Your Ref: OWPC4281
Our Ref: FP/189/14/PL 17-10-2014
Please ask for:
Mr S Davis

Change of use of car port to covered storage area and new fence to enclose from adjoining car port.

10 Cosens Way Felpham

Detailed Proposed Floor Plan

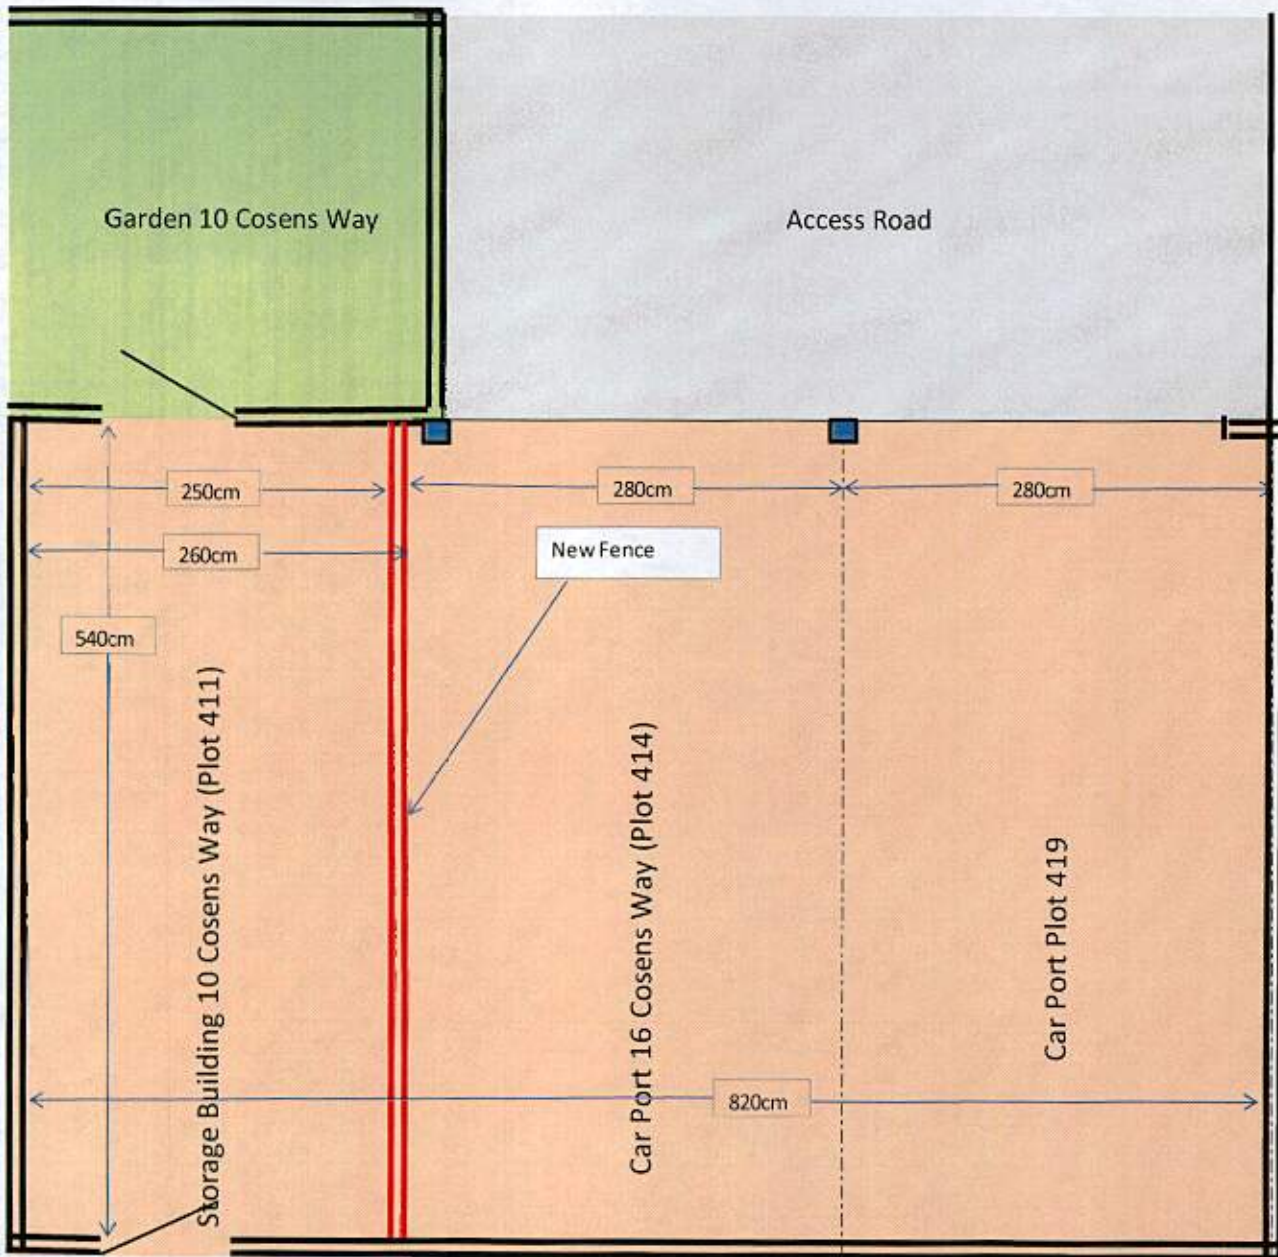
This is my car port and building a fence or wall will inhibit my entering/exiting my vehicle. I bought my house with a port, not an enclosed area. This is a Bovis walkway only.
